Consultation Response from KC, Conservation & Design**2023/92777 71, New Street, Huddersfield, HD1 2BQ****Listed Building Consent for alterations and signage (within a Conservation Area)****Date Responded: 23.10.2023****Responding Officer: Sue Brooks****Responding Ref: HUD 3/939**

Title
GROUND FLOOR SECTION THROUGH ELEVATION

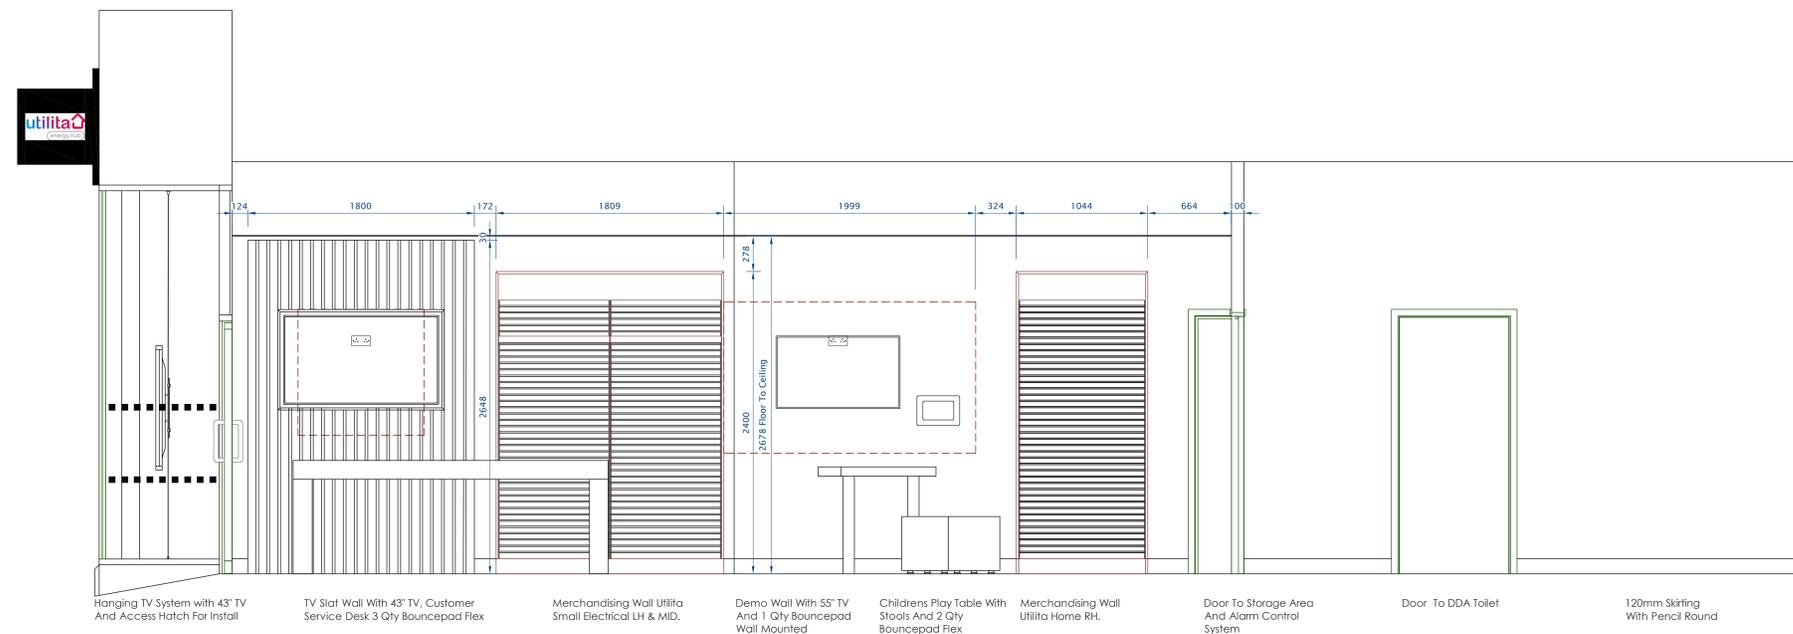
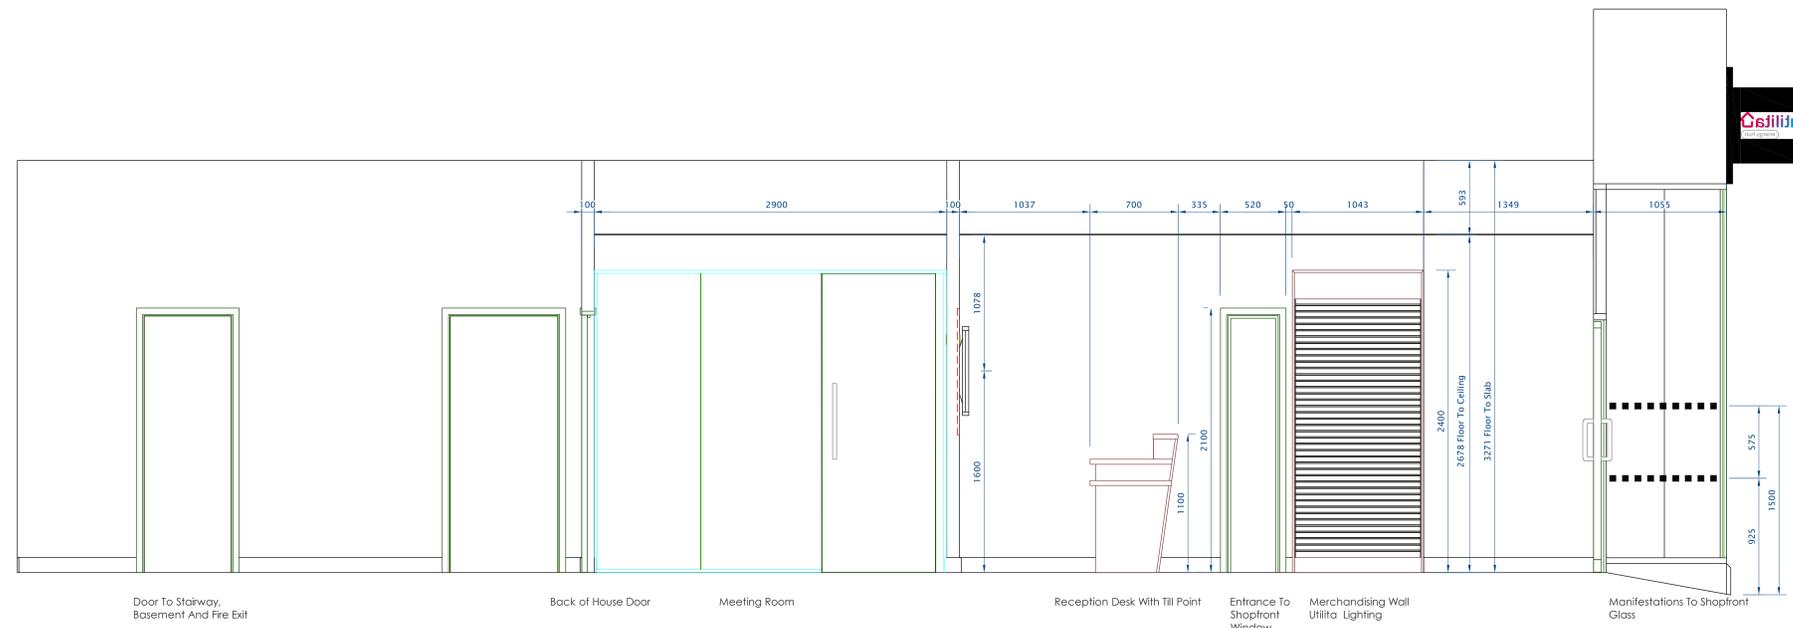
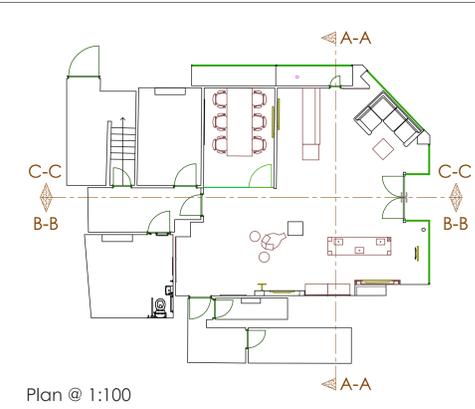
To maintain the traditional character of the shop front, we would recommend that the fascia signage sits flush with the existing, without projecting beyond the depth of the pilasters, and the aluminium fascia panels to be in an eggshell finish rather than high gloss. We would also prefer the projecting signs to be externally illuminated as existing, and not internally illuminated as proposed.

We accept that there are clear public benefits in bringing this vacant retail unit back into use, and the signage could be removed in the future without any impact on the historic fabric. However, the introduction of modern halo lit fascia signage leads to slight harm to the significance of the listed building and character of the conservation area, and we would therefore recommend that the minor amendments above are made to the application.
